From: Sue Howell <Sue.Howell@arun.gov.uk>
Sent: 12 September 2019 17:11
To: Planning.Responses <Planning.Responses@arun.gov.uk>
Cc: Anita Gardner <Anita.Gardner@arun.gov.uk>
Subject: RE: Planning Consultation on: CM/21/19/PL

Comment from Greenspace

Site Address: Land adjacent to Scyld Horsemere Green Lane
Climping BN17 5QZ

Description of Works: Construction of 9 no. dwellings, access,
landscaping and associated works.

Drawing Title
Tree Retention and Protection Plan
Sheet 01

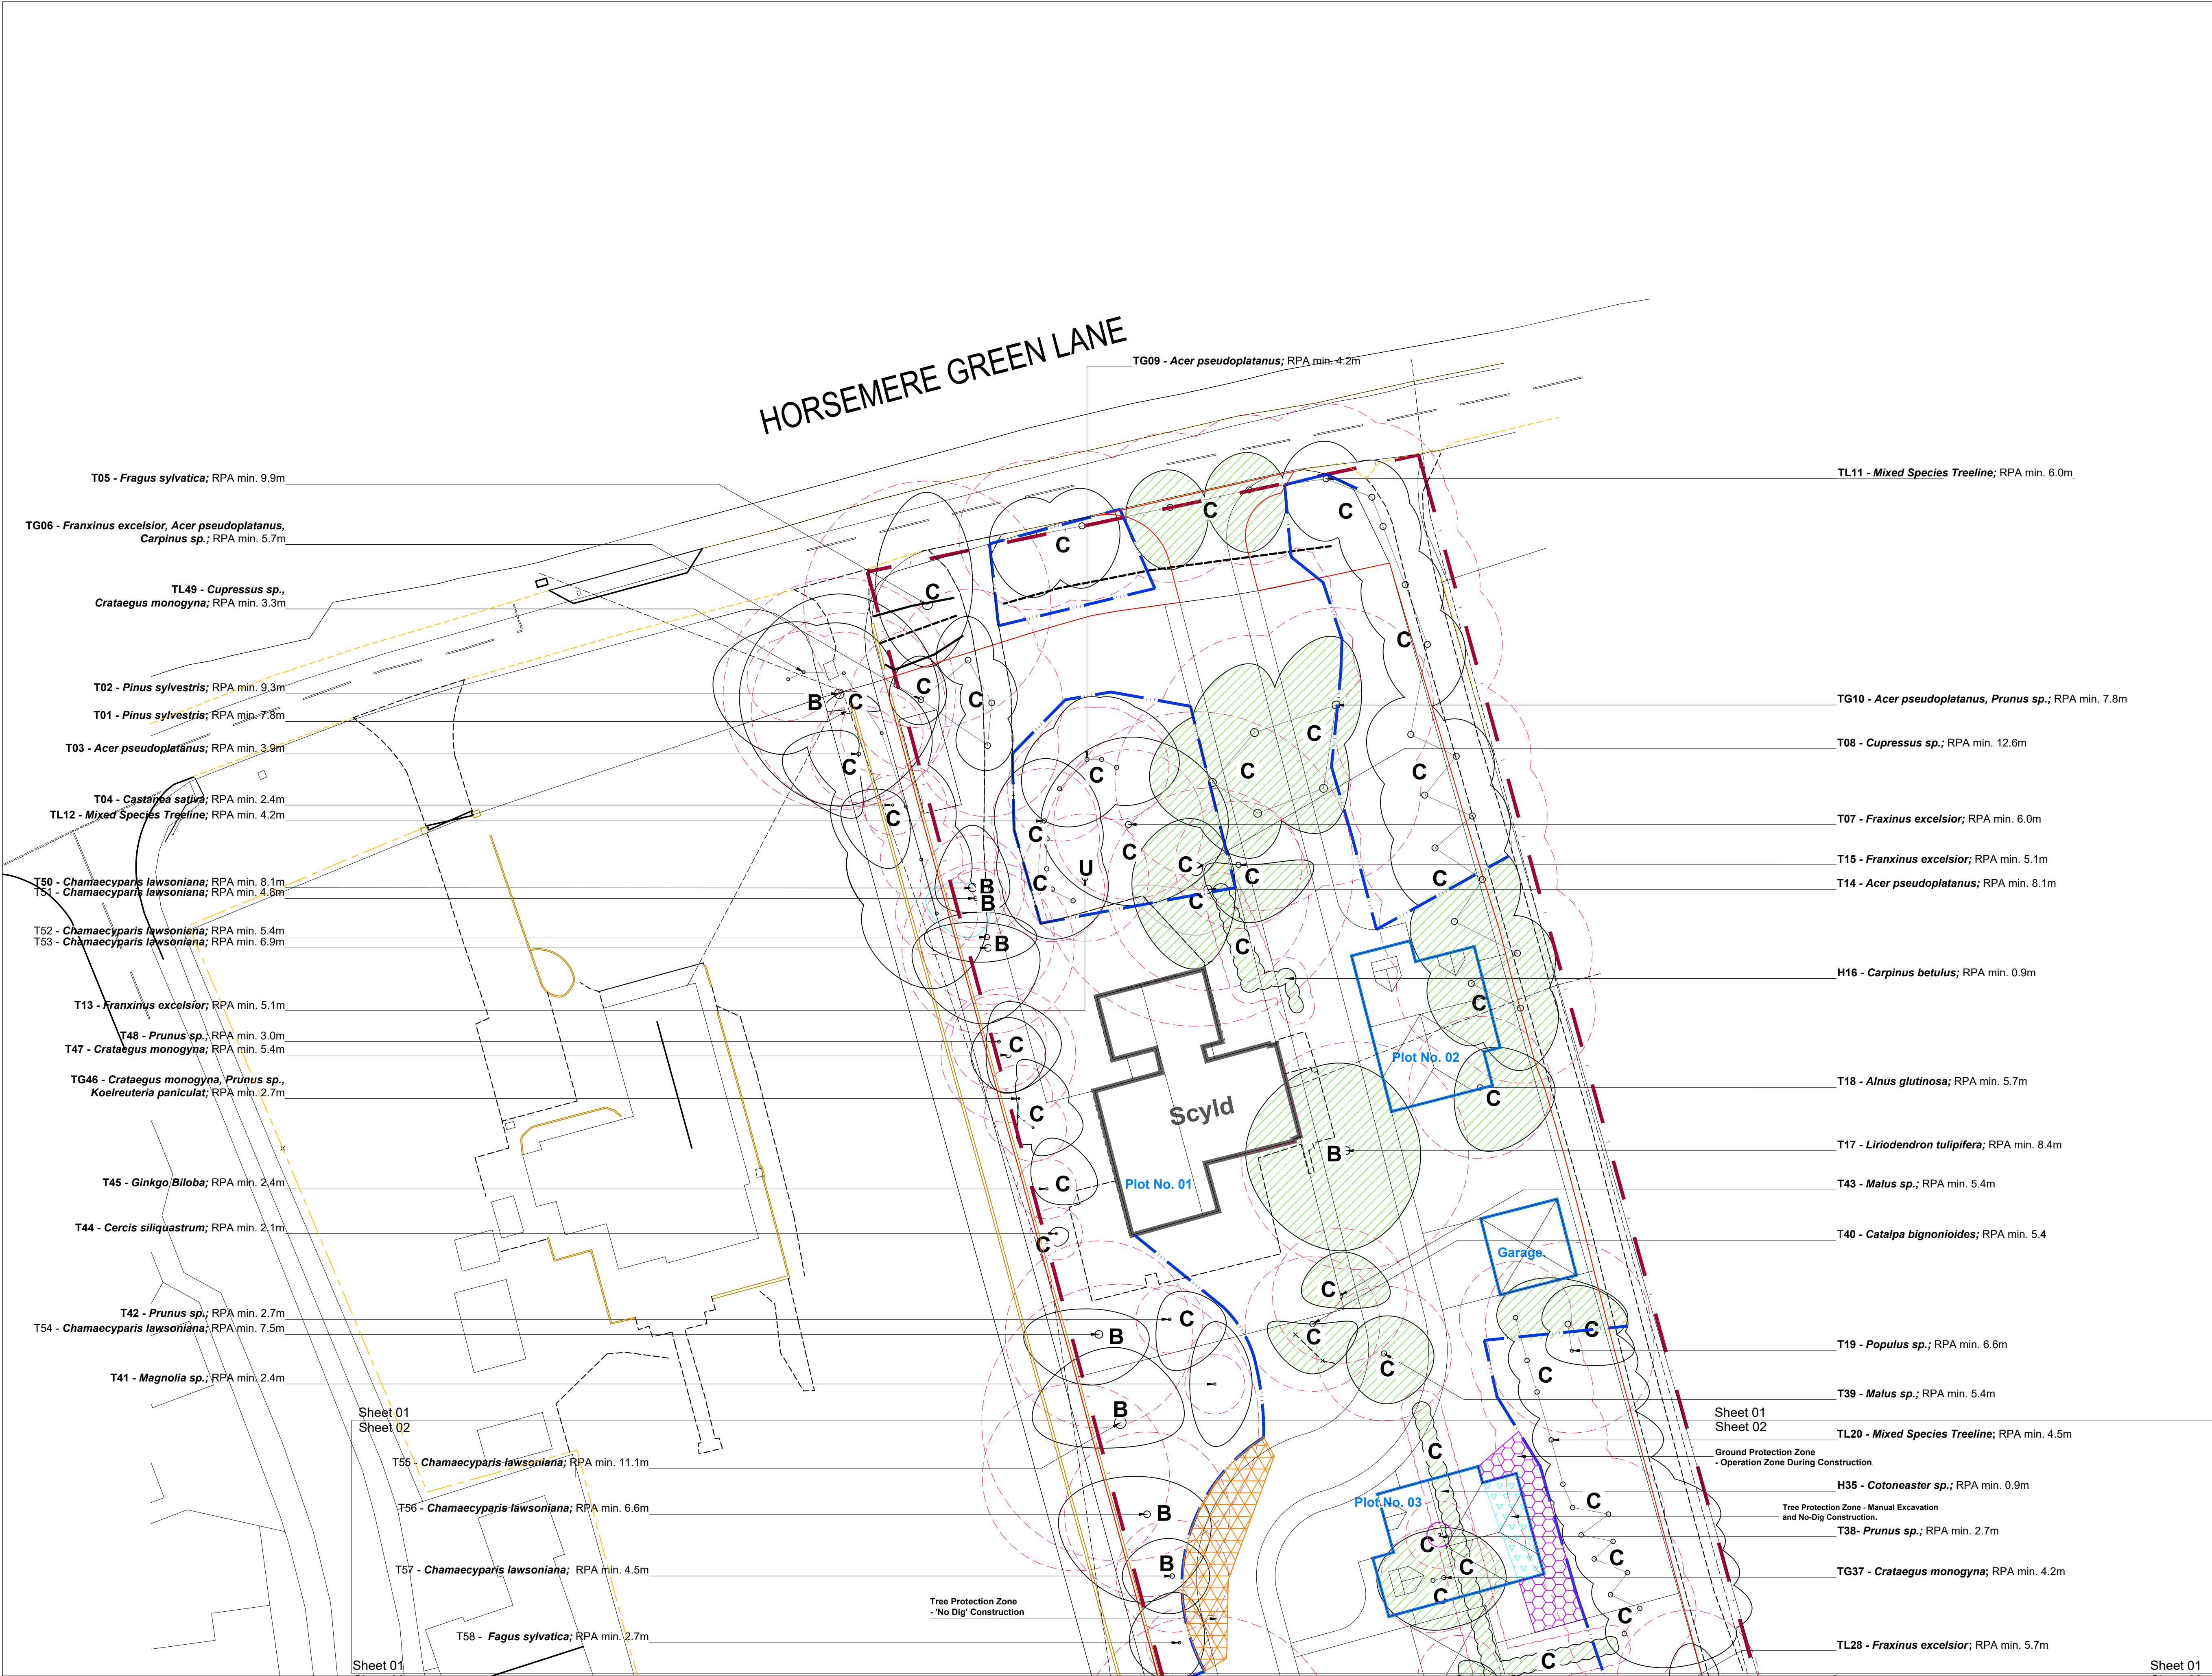
Any further considered tree removal must be in consultation with Arun District Councils Tree Officer. Before construction begins, a tree protection scheme must be in place for any retained trees including trees whose root protection areas fall within the construction zone from neighbouring land. This should be in accordance with BS 5837:2012 'Trees in relation to construction' A quantity of the trees related to this site particularly along Horsemere Green Lane have the potential to be valuable trees giving structure and screening to the proposals.
